May 26th, 2025

Re: SSD-78996460.- 16-24 Lord St & 21-27 Roseville Ave, Roseville

4 3D HEIGHT PLANE - SE

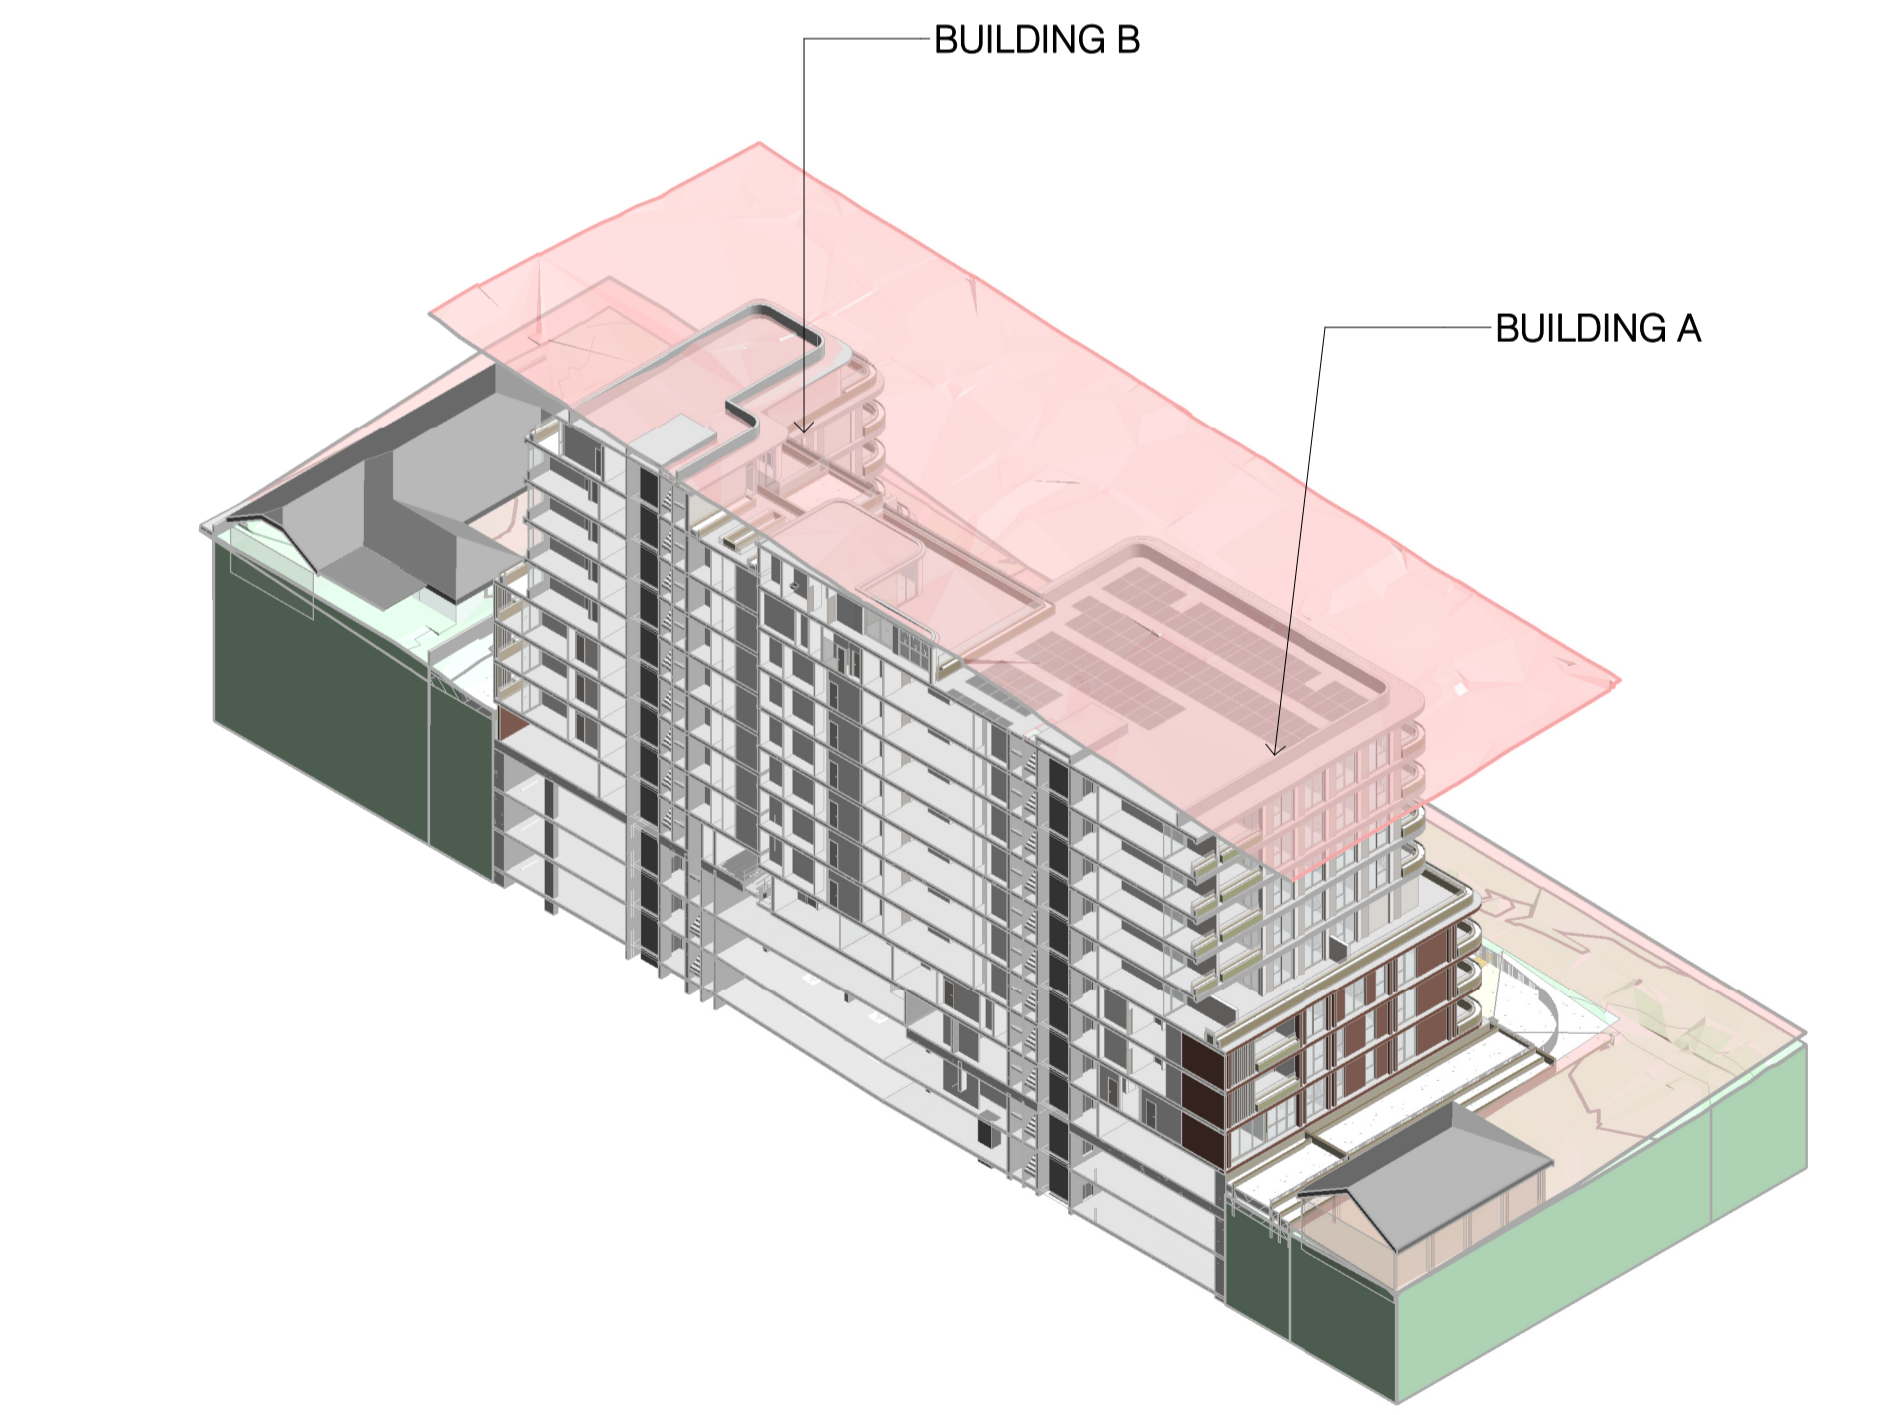
By the inclusion of affordable housing, the proposal takes advantage of a 30% increase in allowable height. But even with this generous allowance the developer (Appendix H Variation Request) seeks a further increase of between 2.3m – 1.6m over various parts of the building. The proposal acknowledges this non-compliance in Appendix B.

This combination of excessive height and inadequate setbacks will result in a visually dominant building that detracts from the character of the streetscape and amenity of neighbouring properties including the Roseville Presbyterian Church at 28 Lord St.
